From: Matthew Eason <mj4.matt@gmail.com>
Sent: 20 May 2021 23:34
To: Iqraa Malik
Subject: Re: FG/89/21/HH Revised plans
Attachments: We sent you safe versions of your files; 25 Ocean Drive - Proposed Elevations REV 5.pdf; 25 Ocean Drive - Proposed Roof and Plan View REV 5.pdf

Unfortunately, this application is still invalid for the following reasons:

Ref - FG/89/21/HH - 25 Ocean Drive

Proposed Elevations
Scale 1:50 @ A1

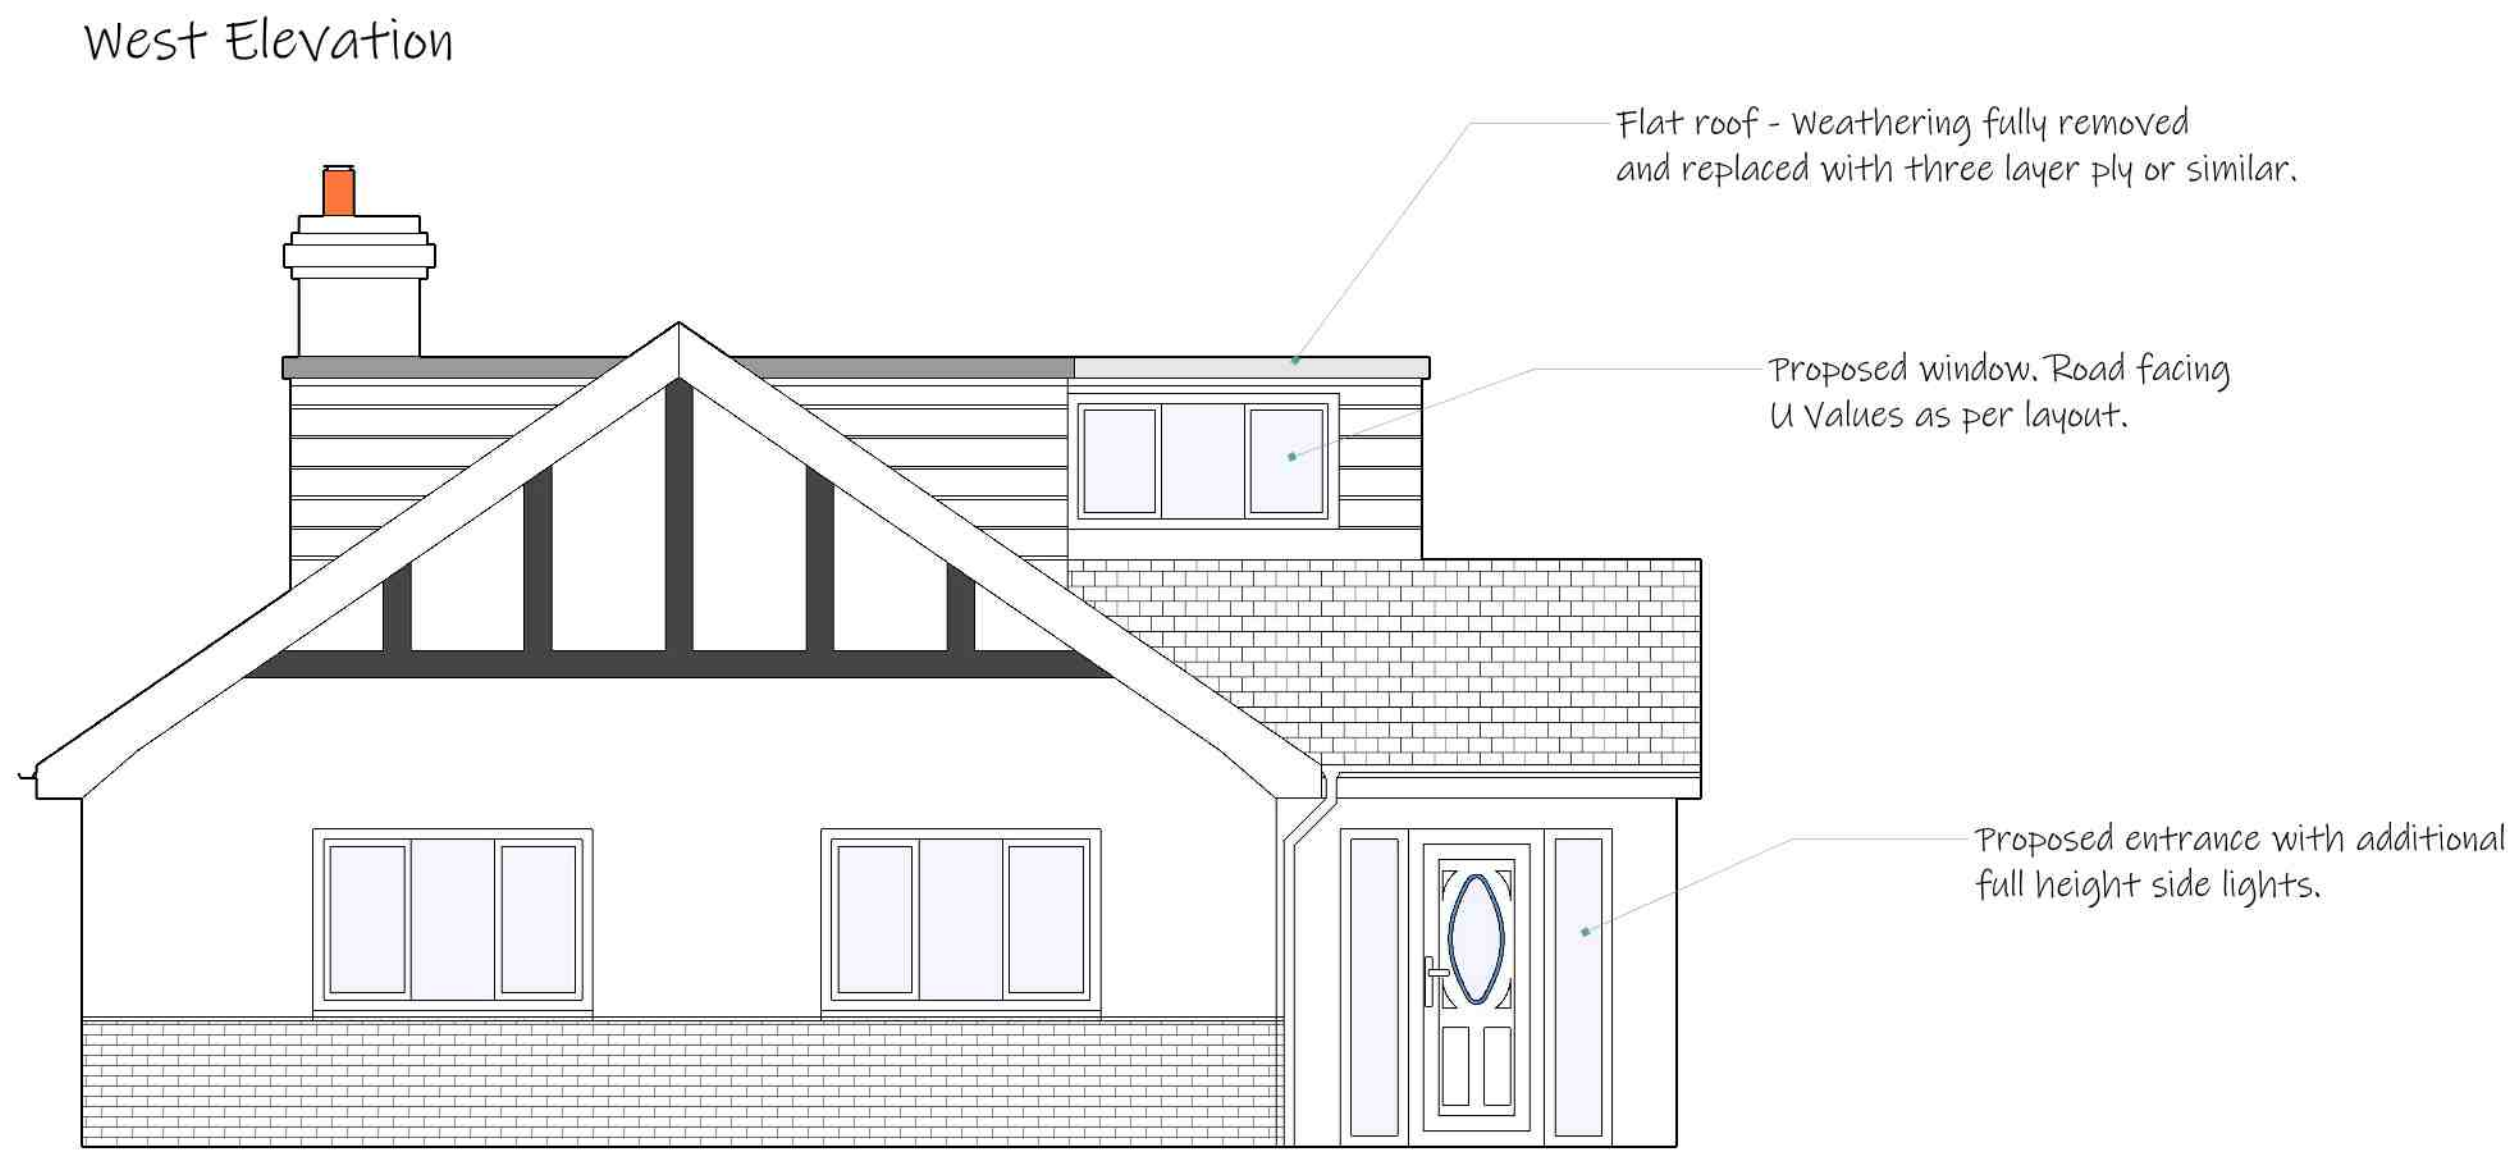
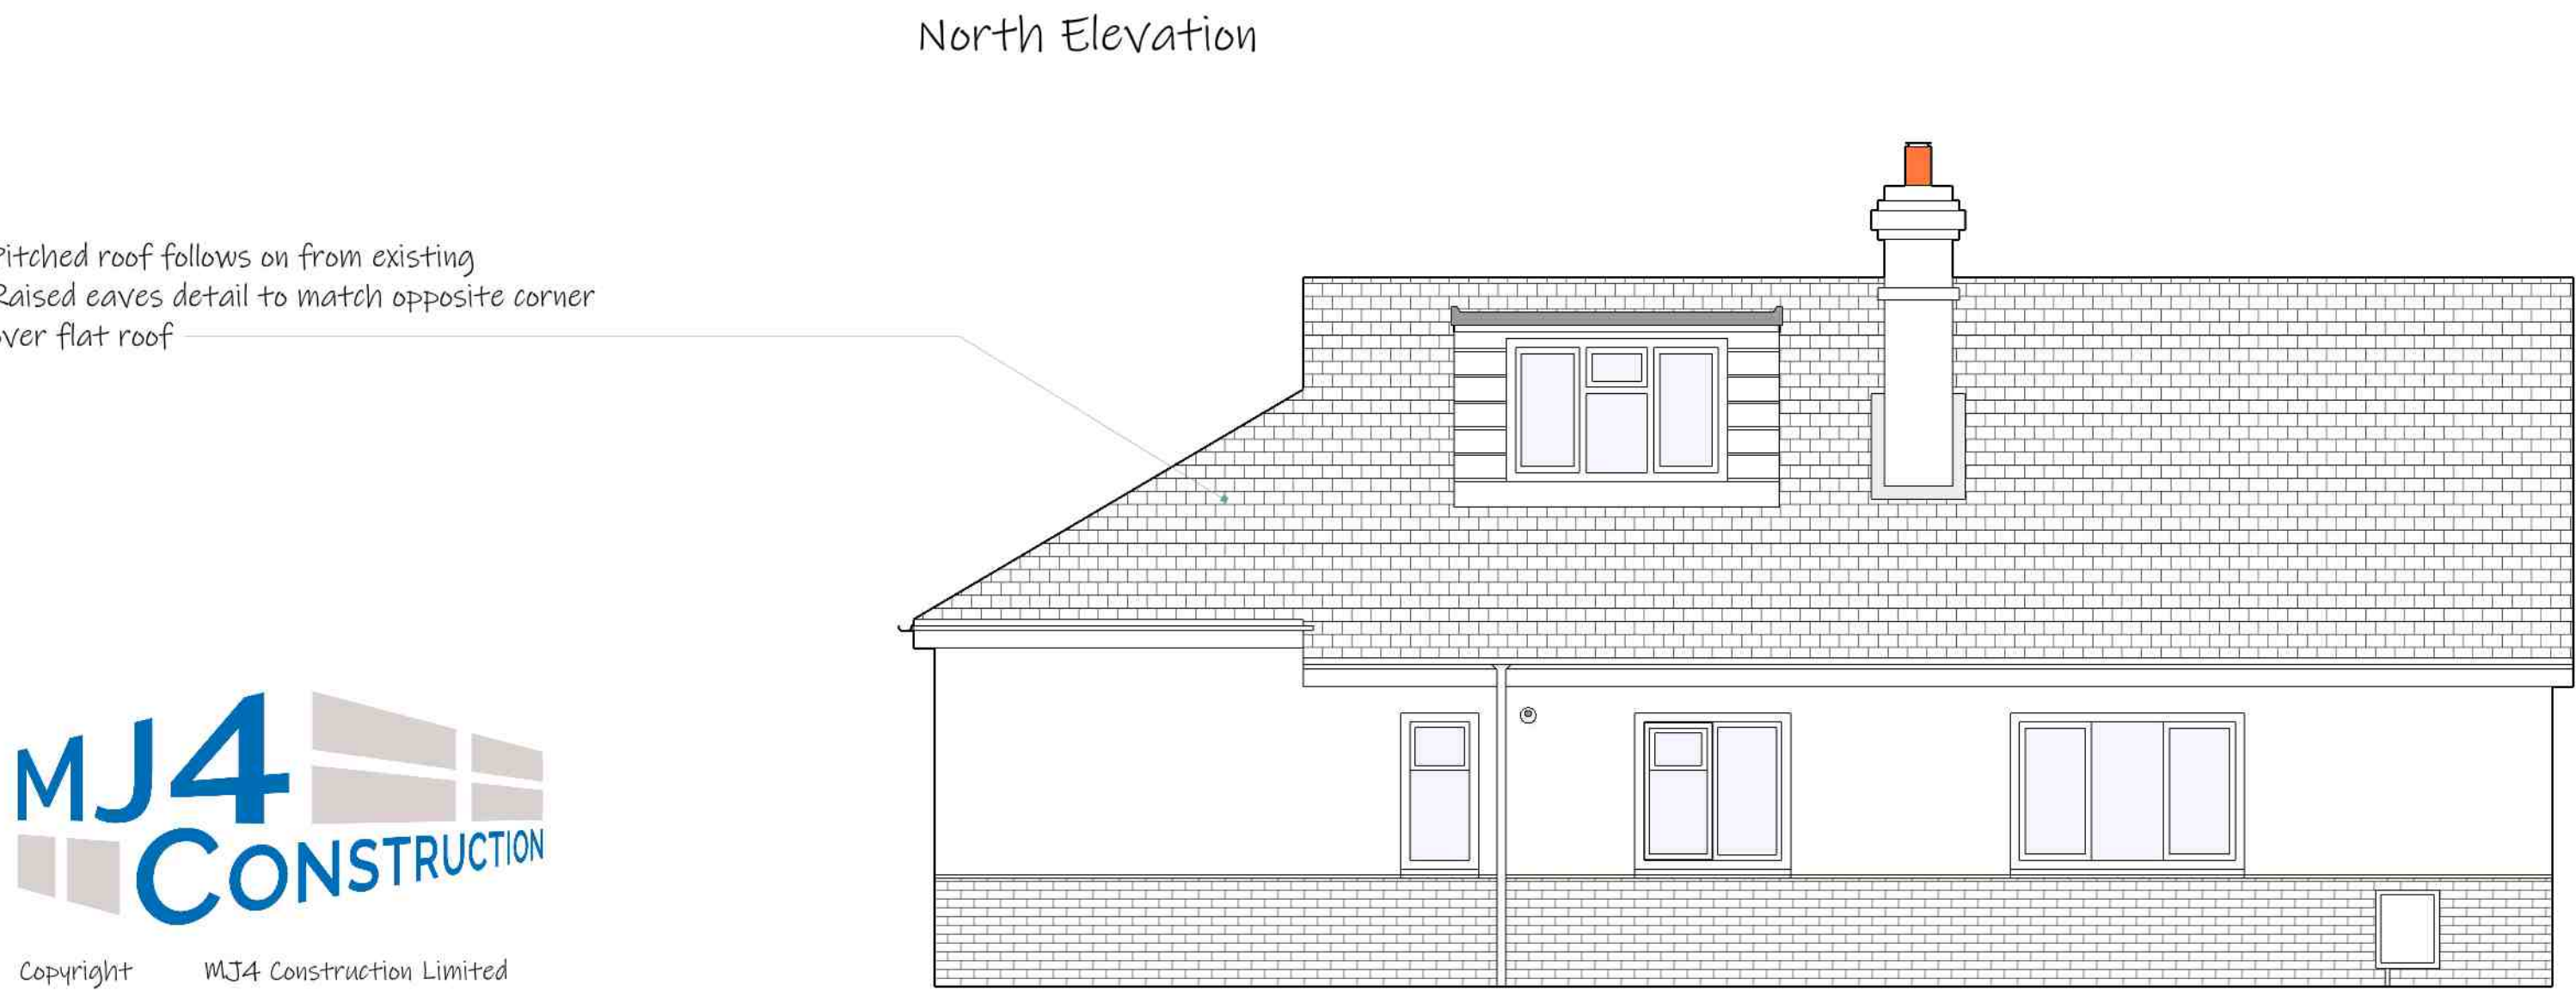
Proposed Plans: The rear window shown on the proposed first floor is missing from the proposed rear elevation

Proposed Plans: The ground floor window placement is inconsistent between the proposed ground floor plan and the north elevation.

North Elevation revised to show the proposed rear extension. This now reflects the plan view and window layout,

There is no window in the proposed 1st floor rear elevation - the proposed pitched roof over the extension intersects this area and it has been removed.

NB's - On the rear elevation i have shown a raised eave detail - this is to reflect the existing raised eave on the opposite side where it was lifted over the existing flat roof. As we can not lower that eave i have detailed the fascia to be the same depth but with a reduced soffit so we can maintain the existing pitched roof line.
